Demolition of existing garage & outbuildings. Alterations to external materials (including change from thatch to clay tiled roof and brick/stone to fibre cement weatherboarding and coloured render). Alterations to existing fenestration, including to 2 no. ground floor rear bay windows, and addition of first floor front dormer, enlarged balcony at first floor level at the rear. Replacement garages.

The Breakers 29 Tamarisk Way East Preston

Thank you for your internet representation made on 12th February 2020 which has been recorded as '**an objection**' with the comments as follows:

Elevations as Proposed

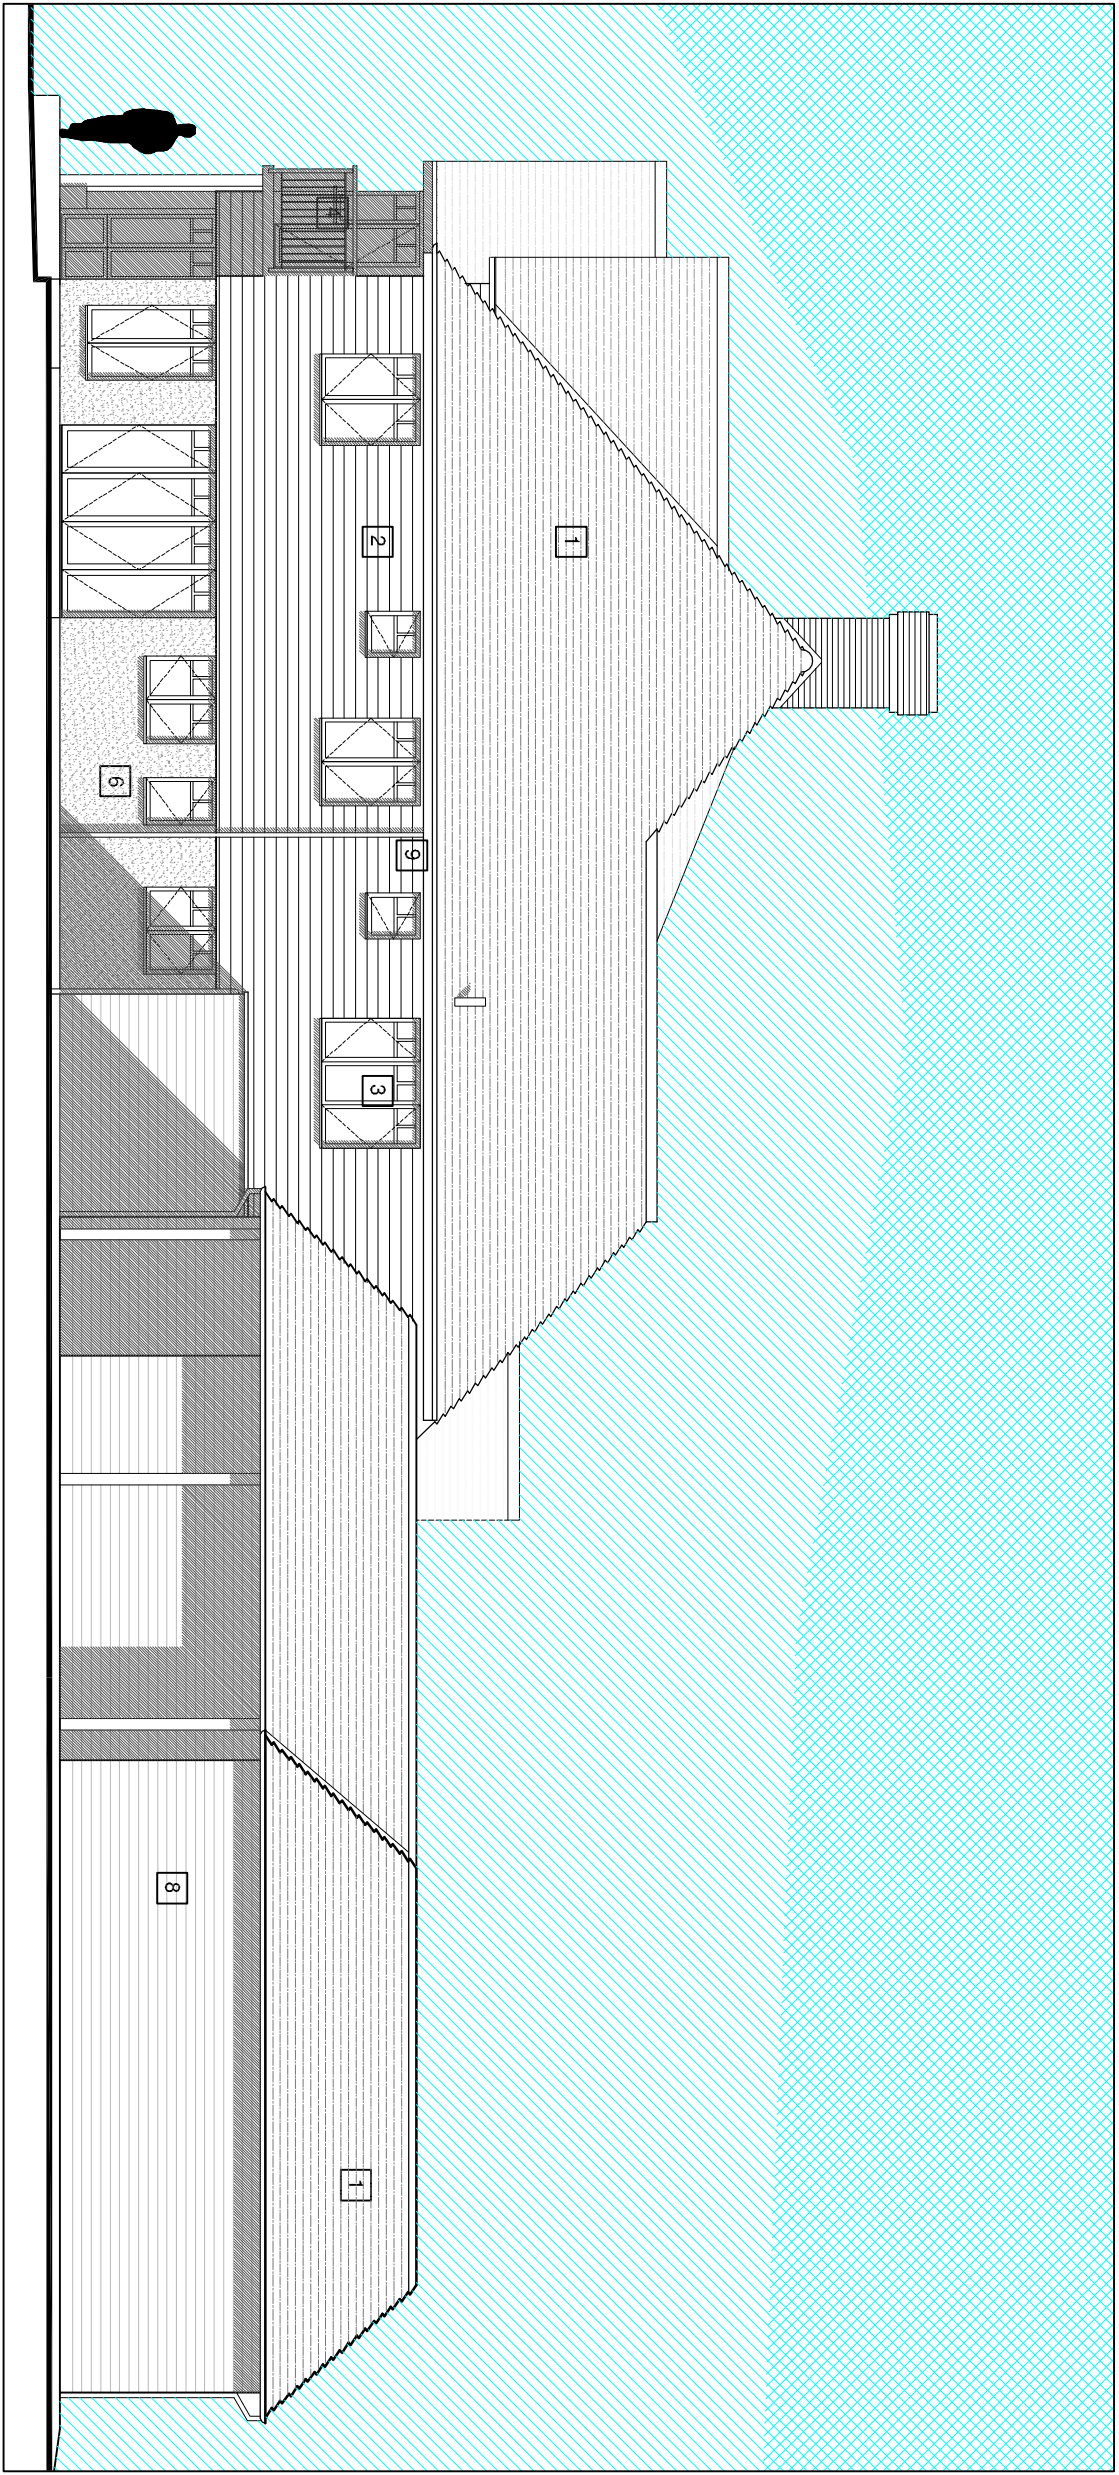
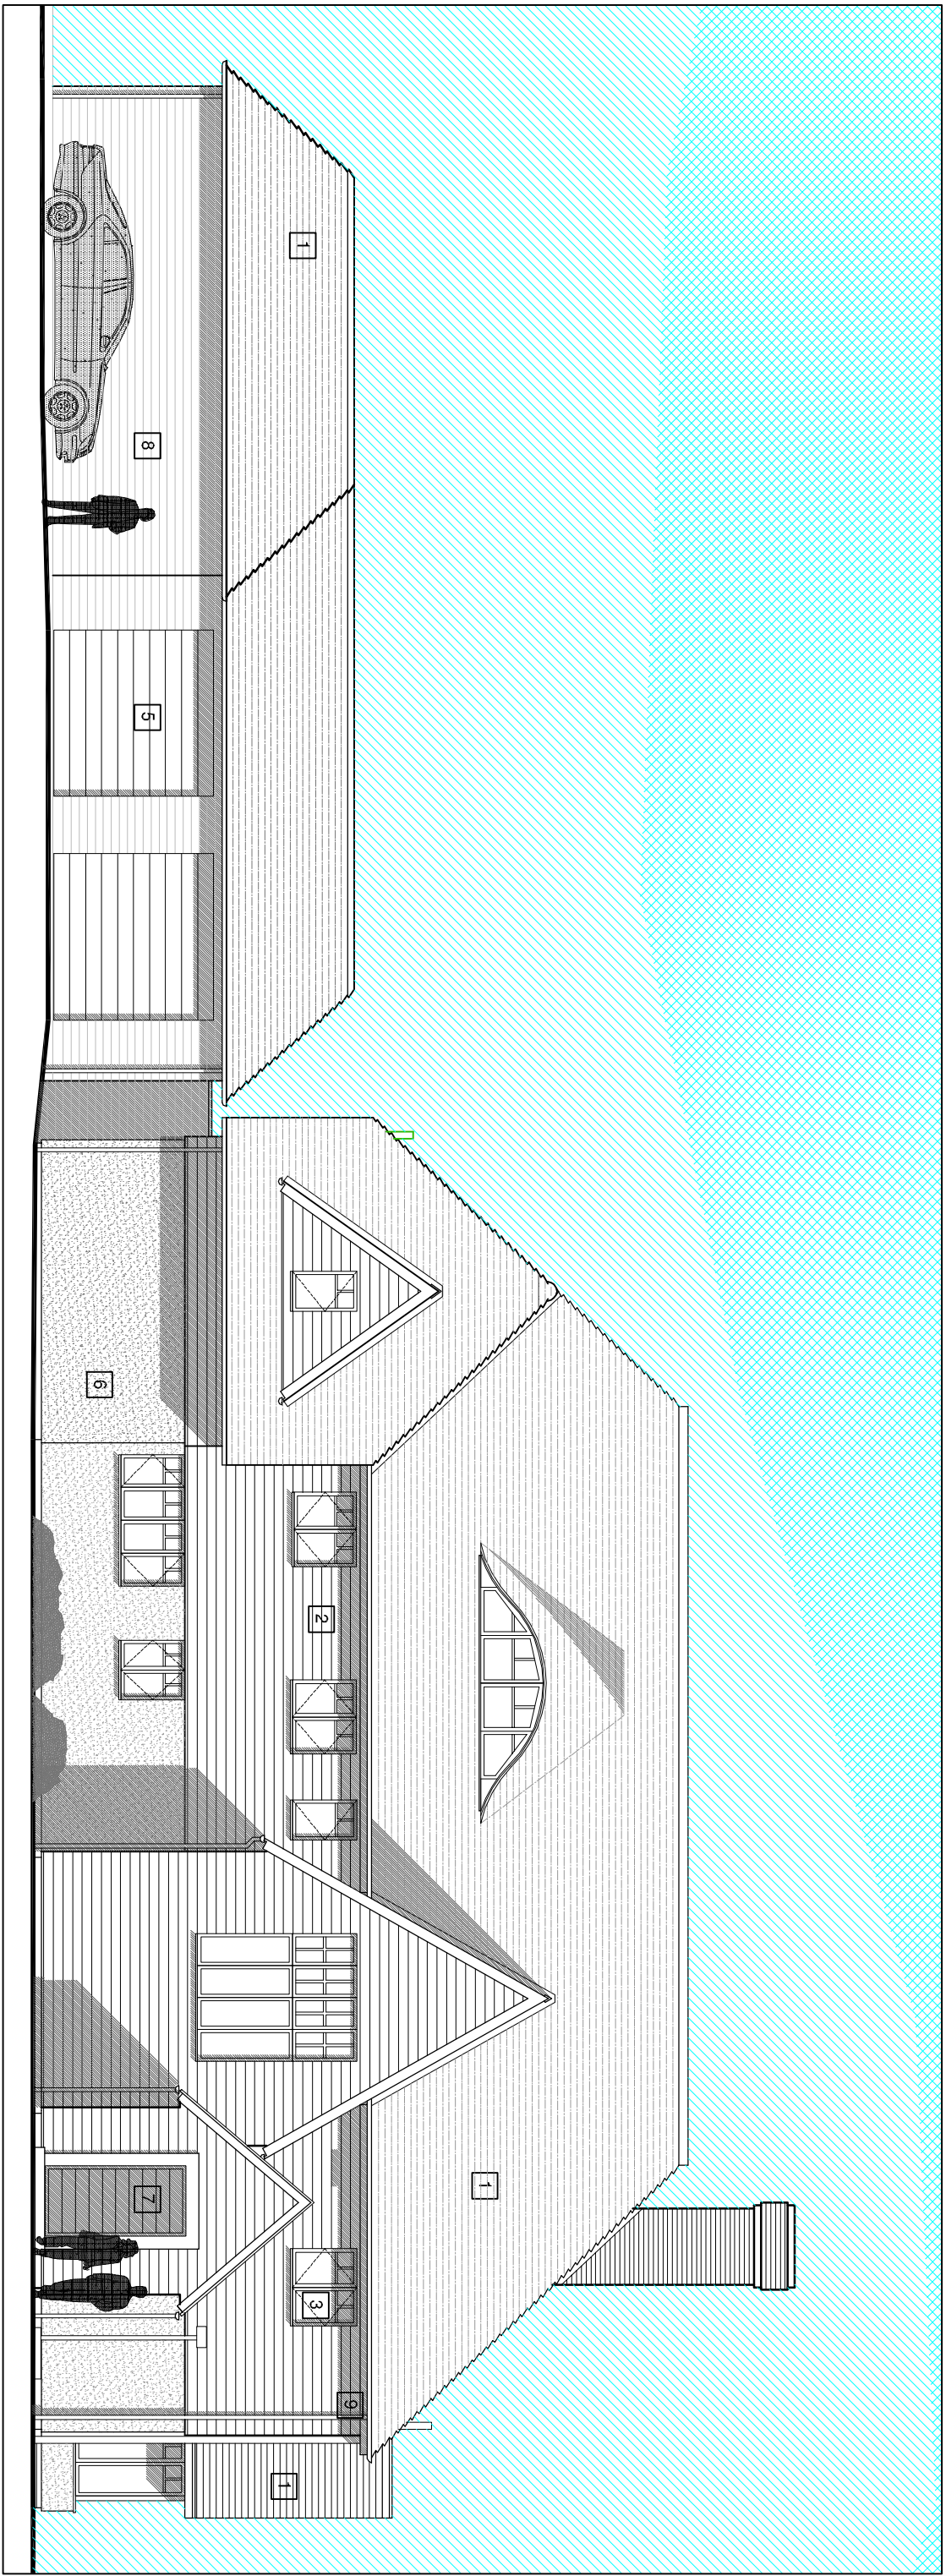
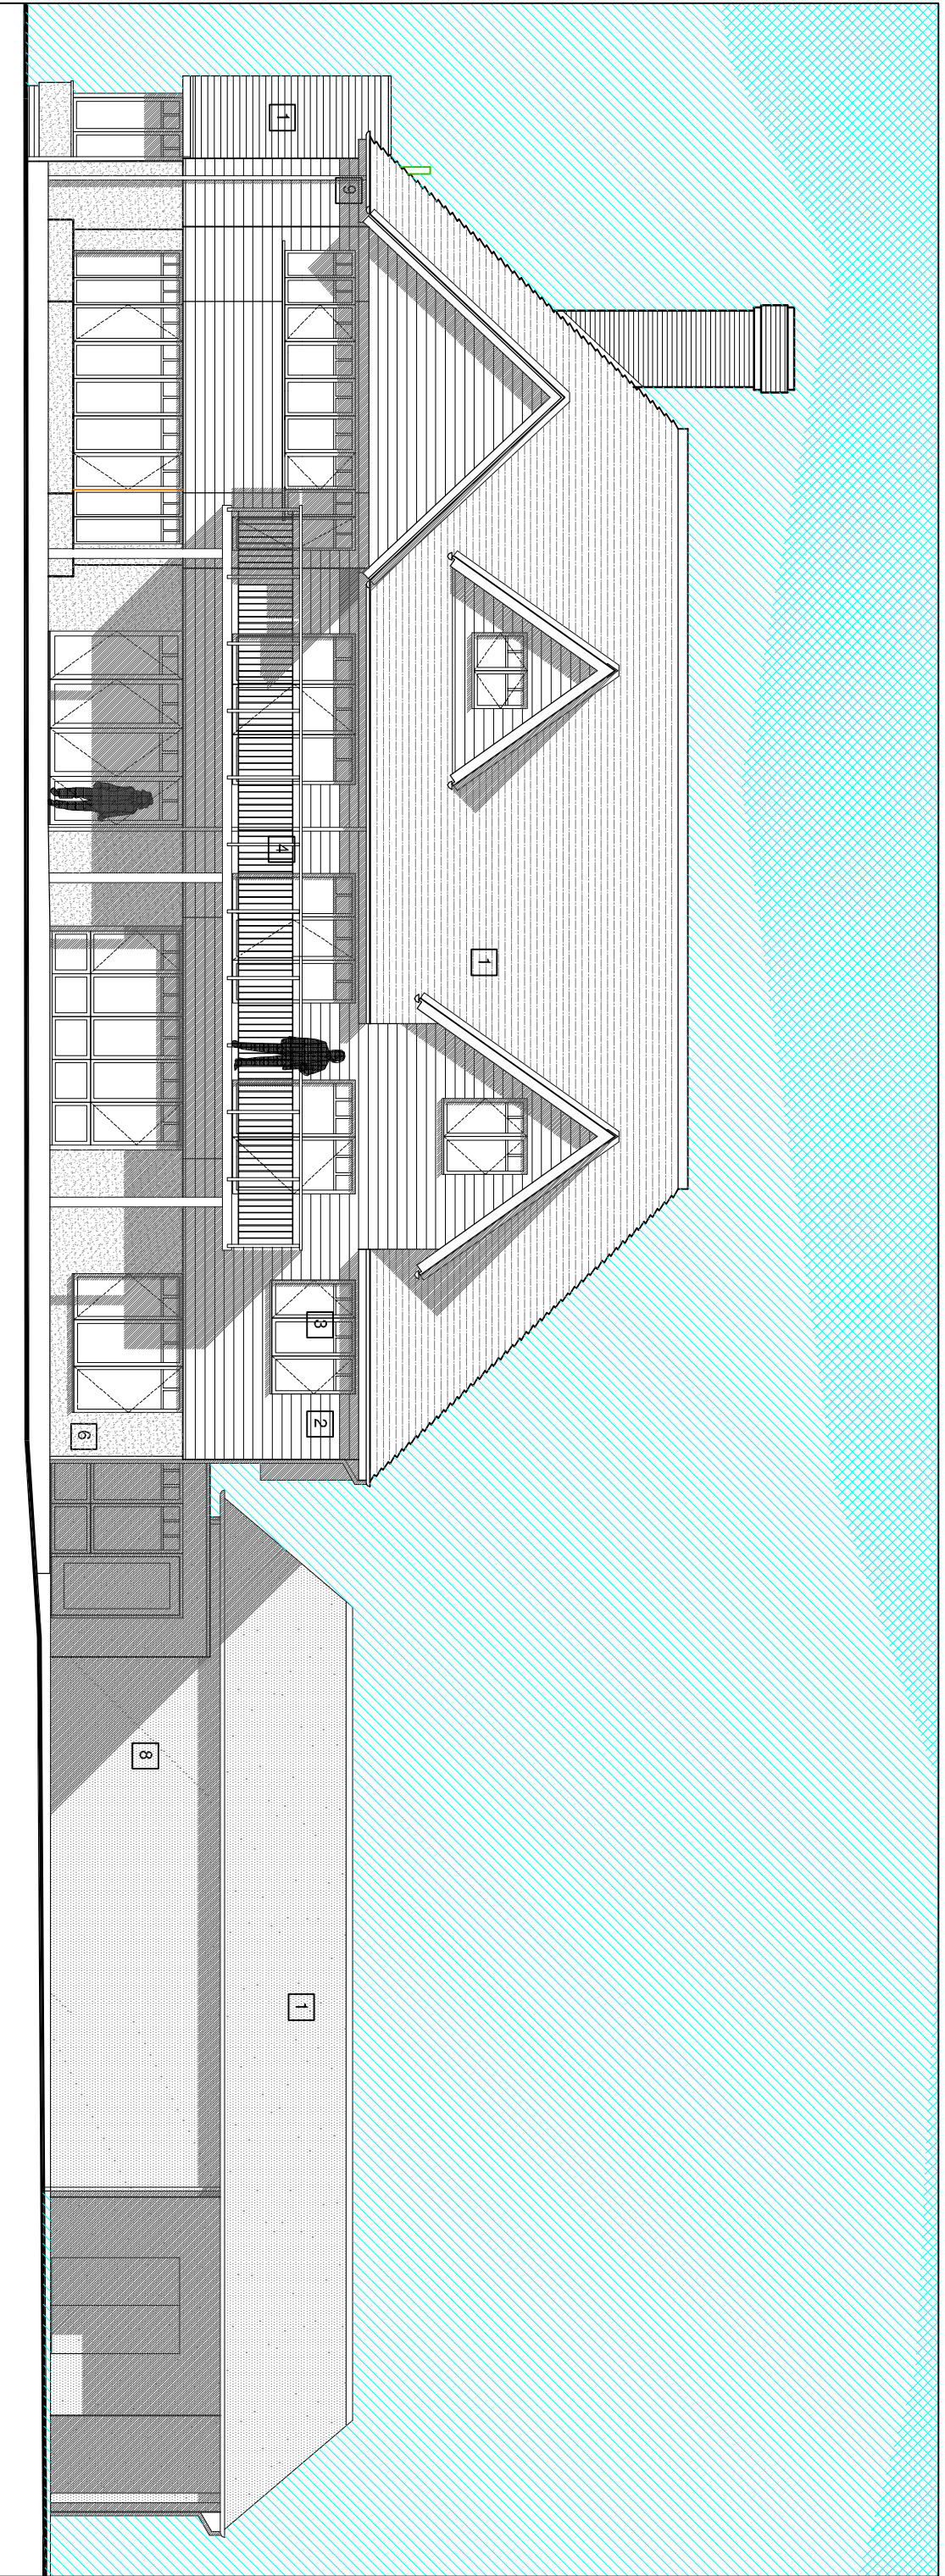
The applicant has stated that the proposals would be diametrically opposed to these objectives, by writing in the Planning Statement that his objective is to produce a house in the New England style, by replacing the thatched roof with tiles and adding fibrecement boards to the upper storey of the outer walls. The proposed 1.95 metre brick wall along the road would transform the setting of the house. The present render and stone wall is a valuable part of the setting that should be preserved.

The applicant wrongly asserts that a New England style house would reflect the design of neighbouring properties. The two neighbours to the west are in Arts and Crafts style; one neighbour to the east is nondescript while the other is Arts and Crafts. A New England style house would look out of place among the Arts and Crafts style houses that now create a harmonious and attractive group.
